**From:** Loveday, Mike, Vodafone Group <mike.loveday@vodafone.com>  
**Sent:** Thursday, 9 May 2013 3:07 PM  
**To:** Public Hazzard's Office Email  
**Subject:** [Correction and Apology]: MP 09\_0066 MOD 6 - Chatswood Albert Ave/Thomas St Development Concerns

**From:** Loveday, Mike, Vodafone Group  
**Sent:** Thursday, 2 May 2013 5:12 PM  
**To:** The Hon. Brad Hazzard (MLA), Minister for Planning and Infrastructure  
**Subject:** MP 09\_0066 MOD 6 - Chatswood Albert Ave/Thomas St Development Concerns

SHADOW DIAGRAM
21 SEPT

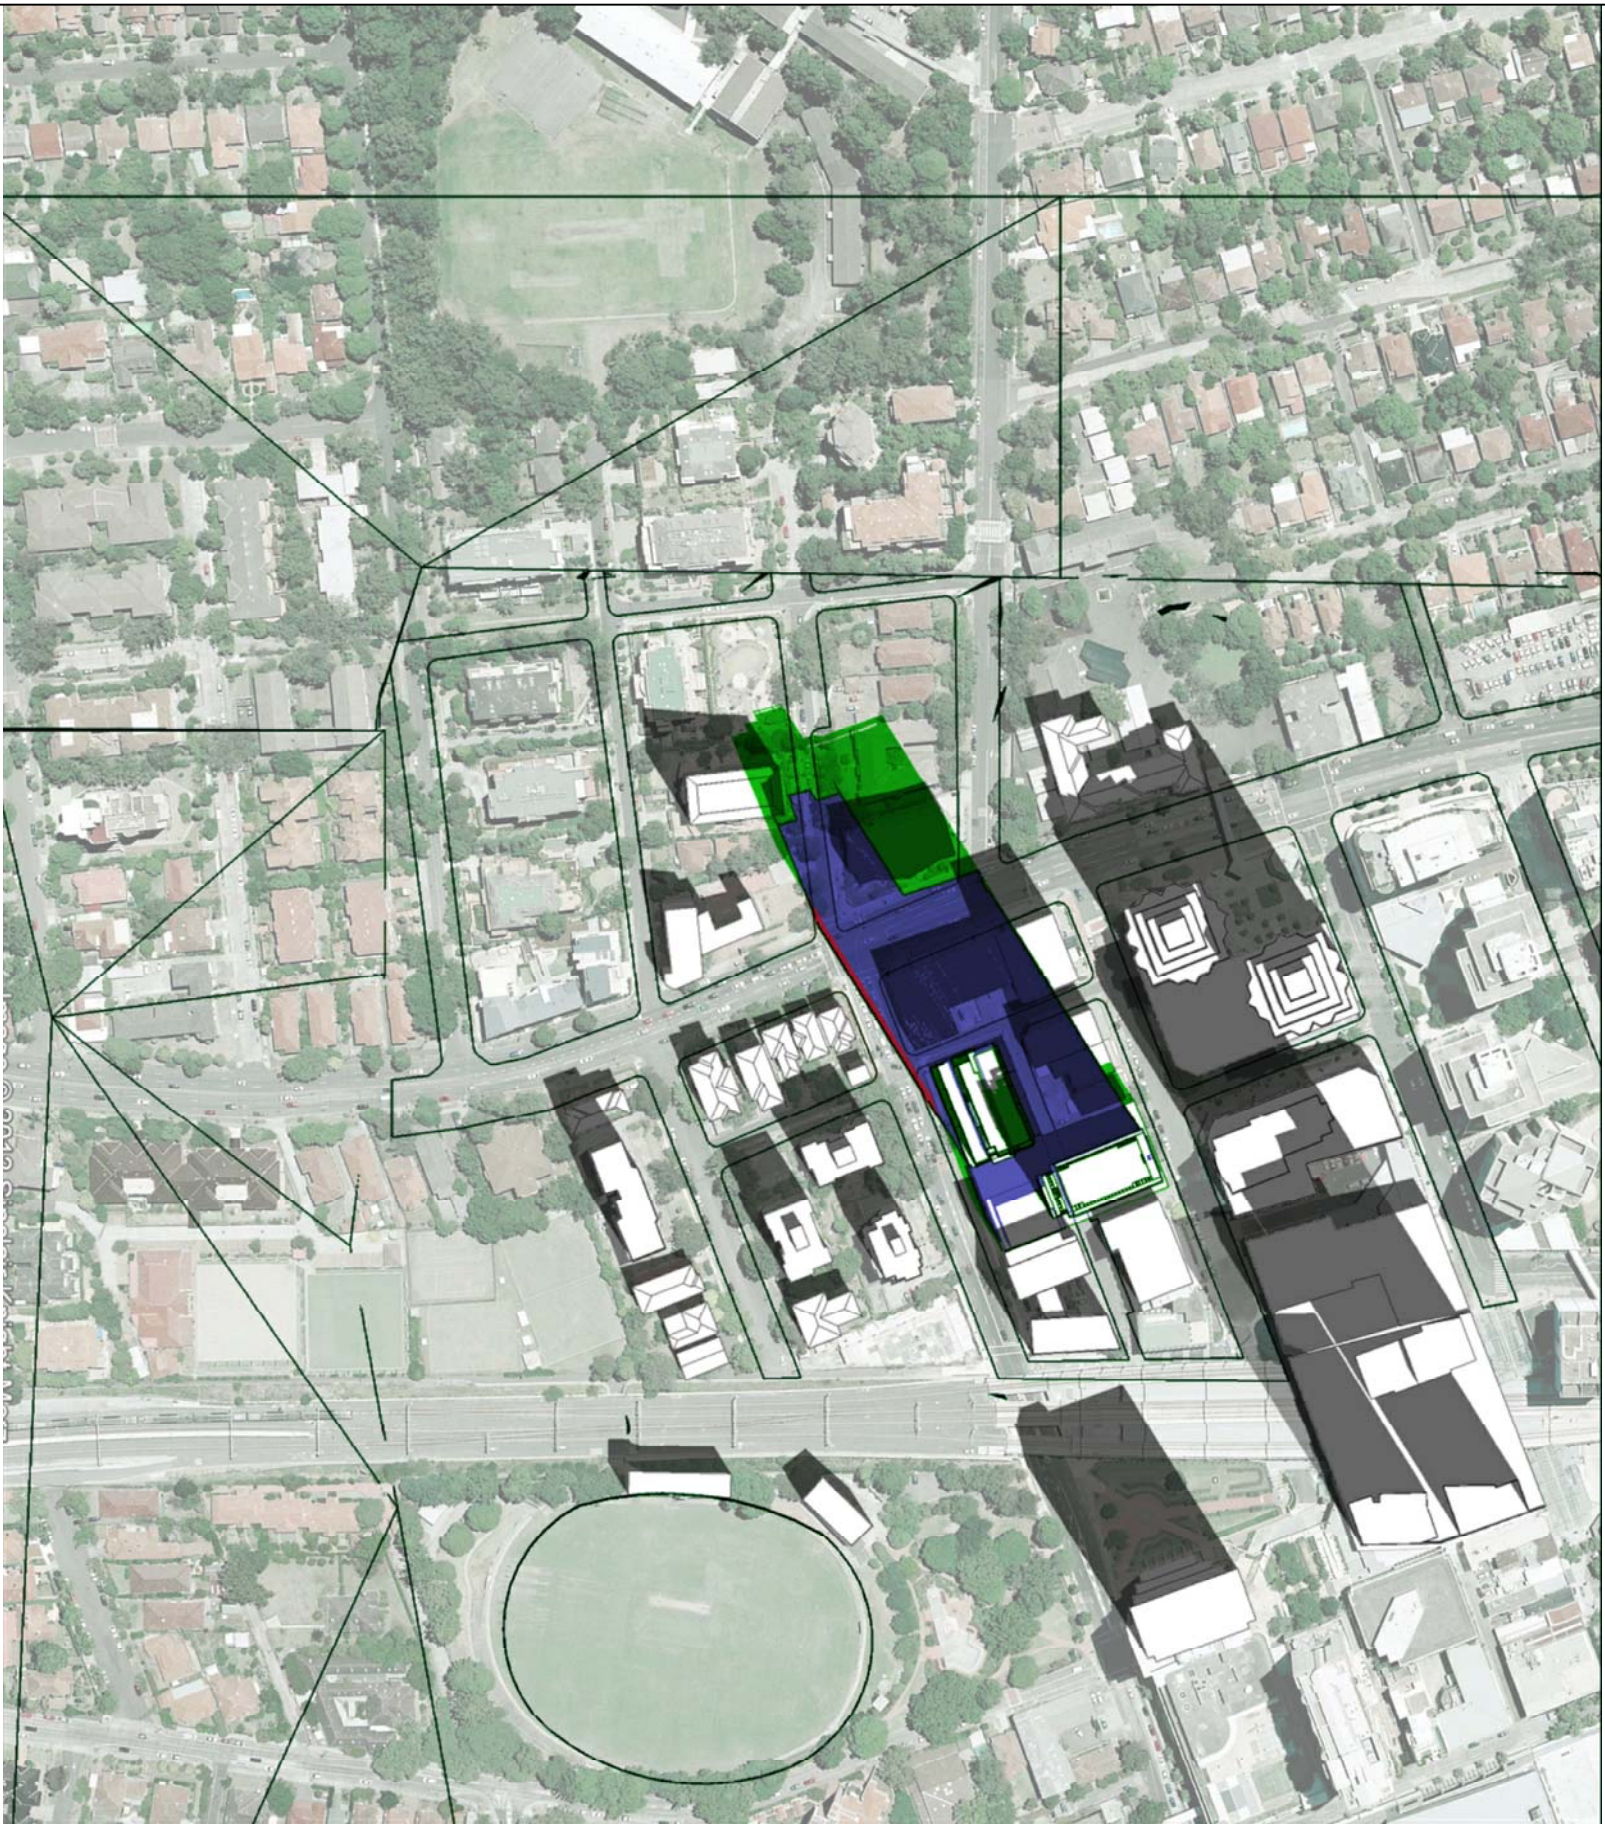
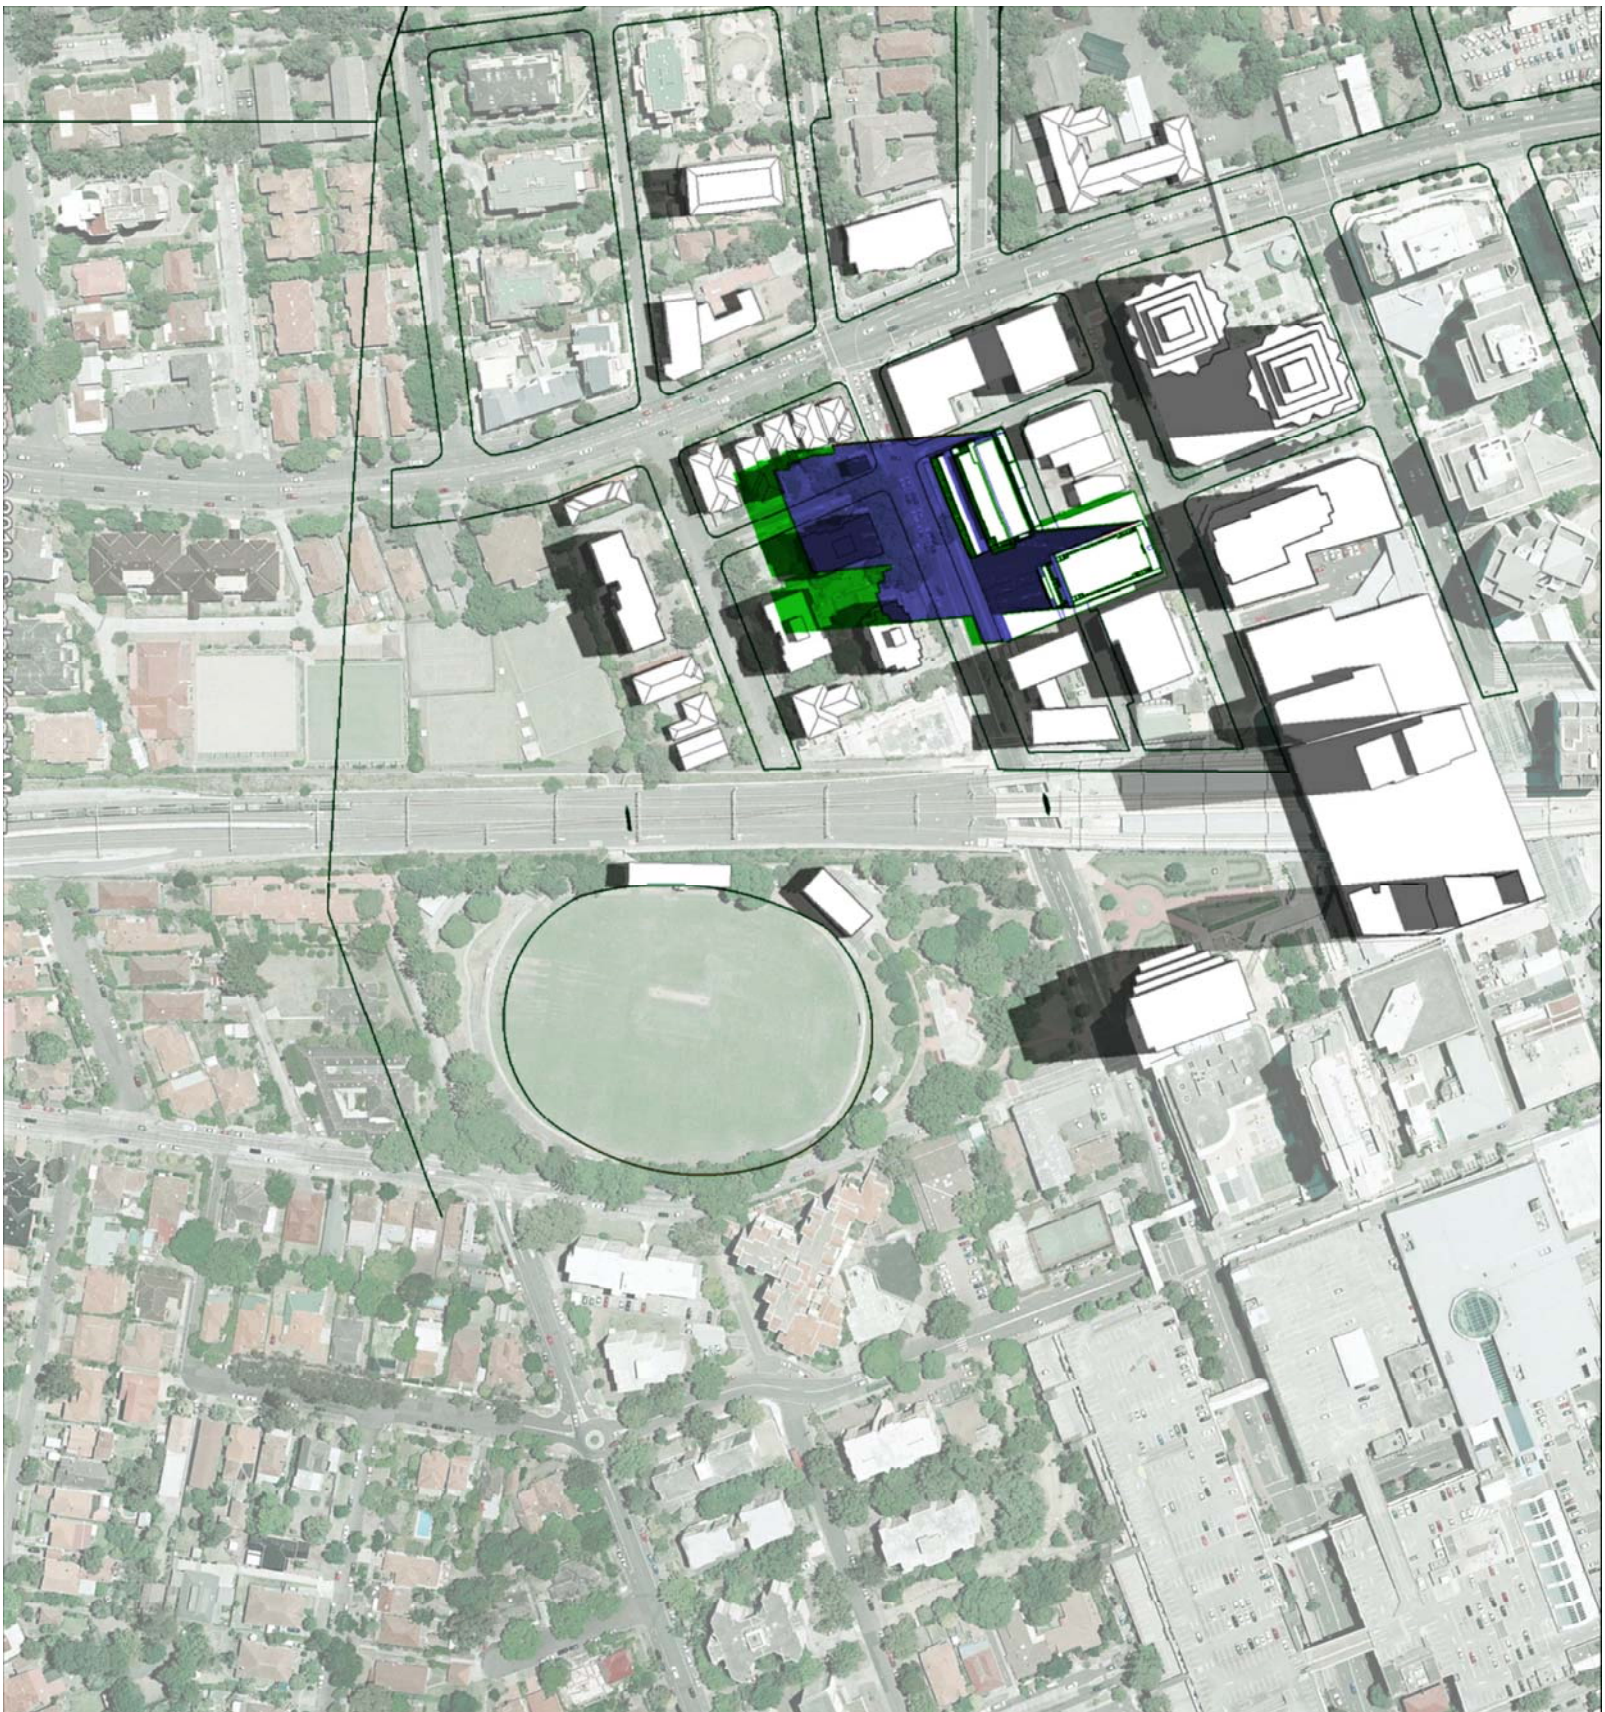
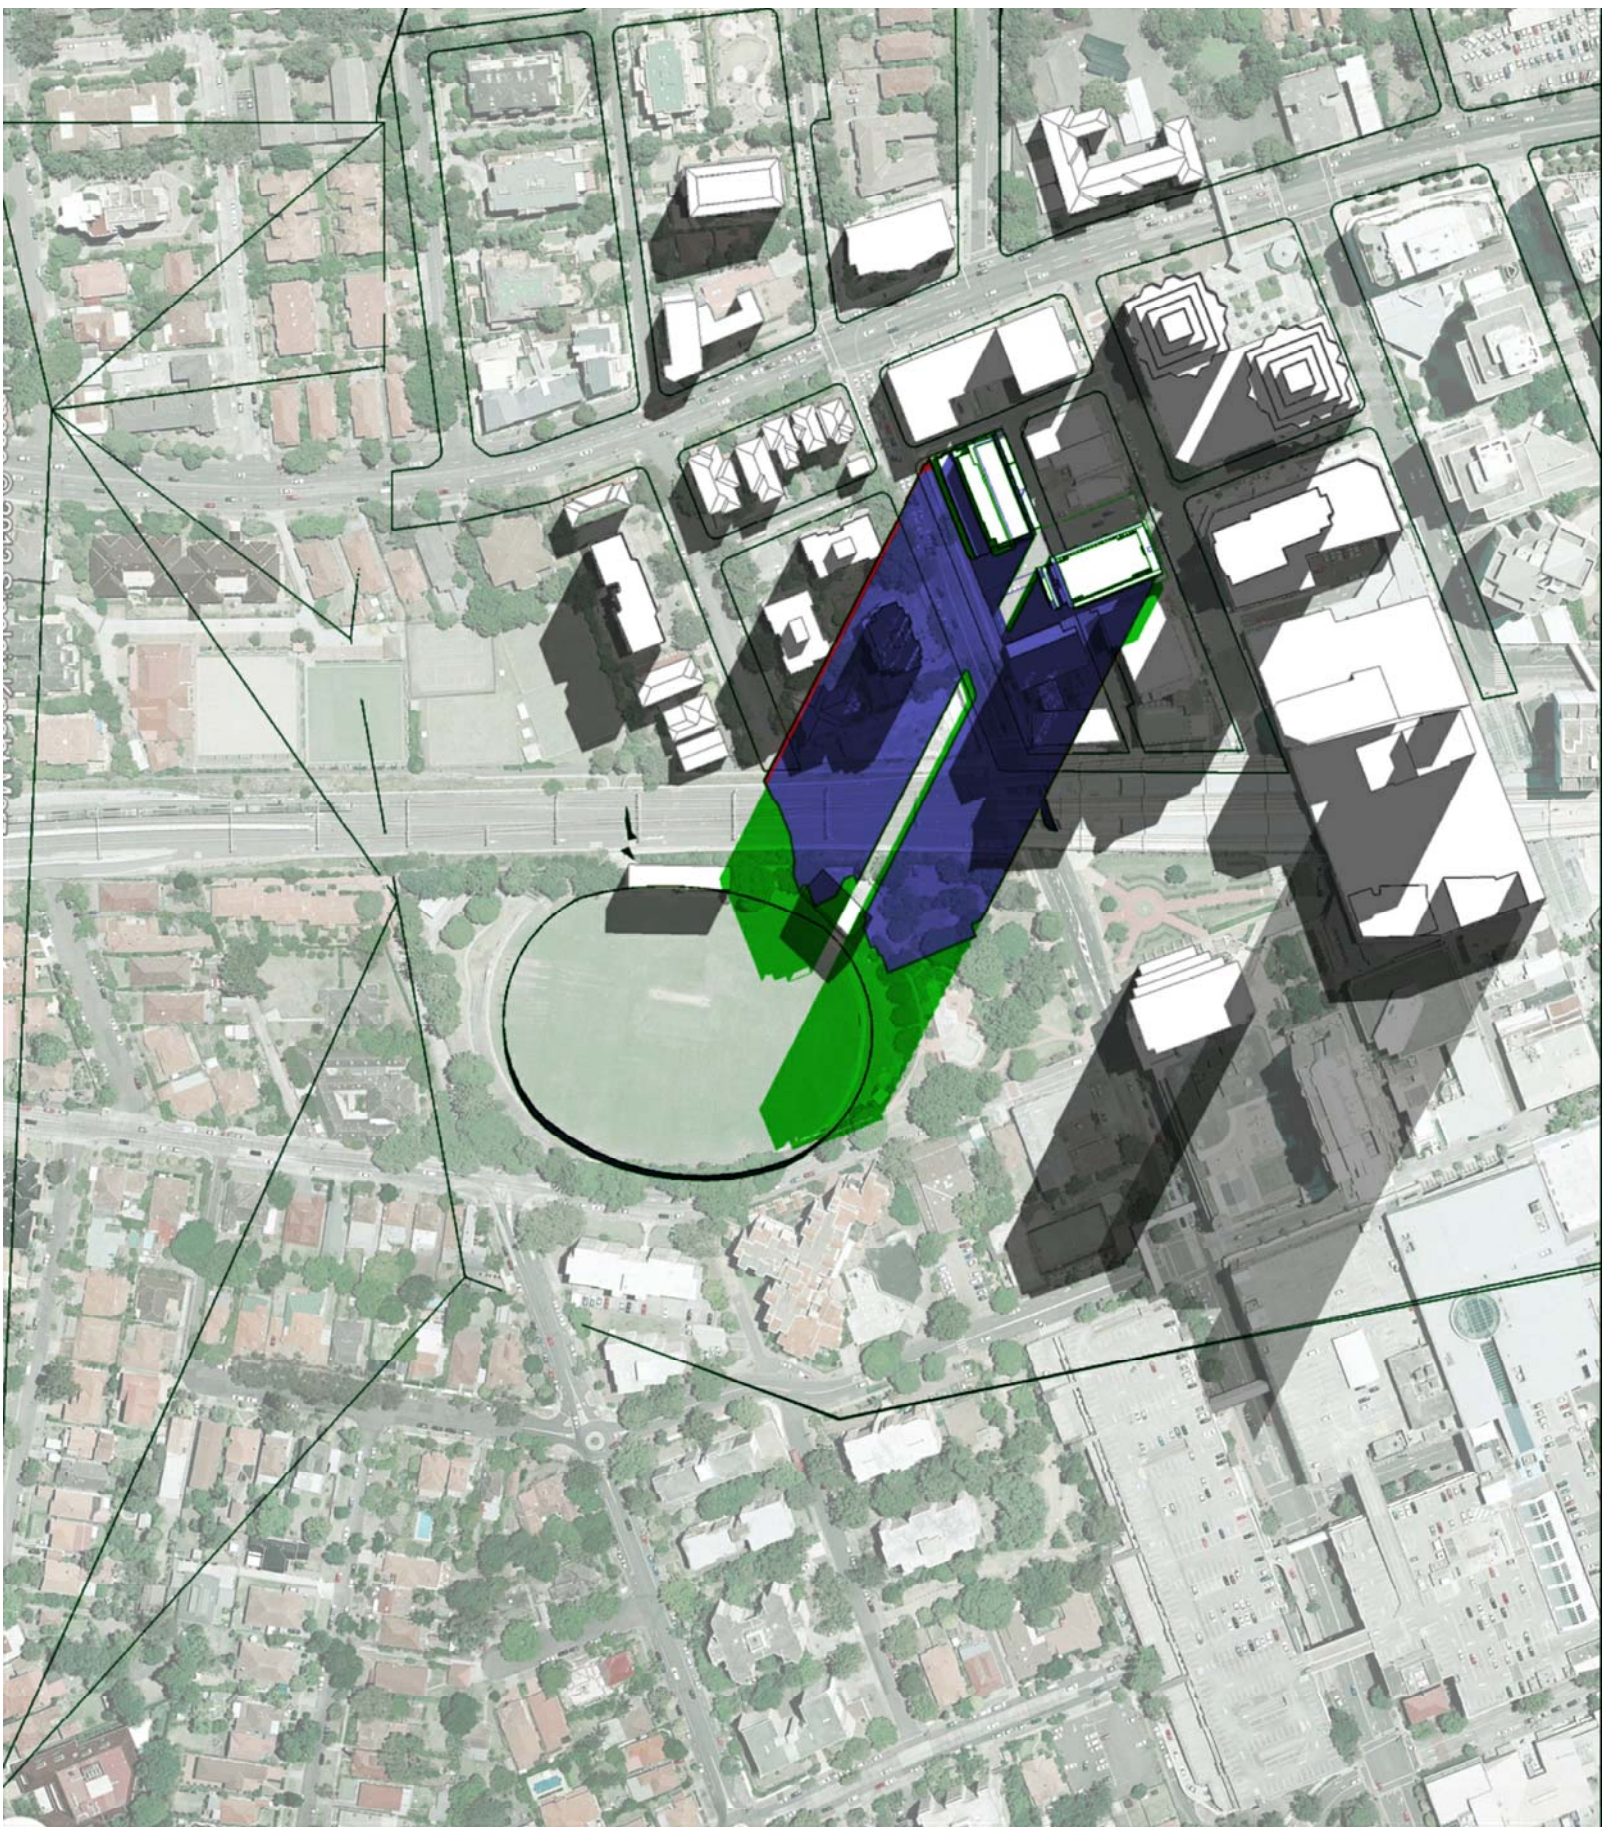
Tower 2 in particular being longways across the block (facing north) which due to the bulk form of the rectangular profile will cause excessive massing impact, loss of solar access, and shadowing to all of the smaller 3-4 and 8 storey residential buildings to the immediate south on the residential fringe of the CBD and the prized nationally significant Croquet and bowling greens and Chatswood Oval.

Massing Impact from the bulk form of Tower-2 as well as loss of solar access and shadowing will be further excessive given that this tower is longways across the site. Being a north facing rectangular bulk form, it will shadow the much smaller residential fringe to the south including the nationally prized Chatswood Croquet and Bowling Greens and Chatswood Oval.
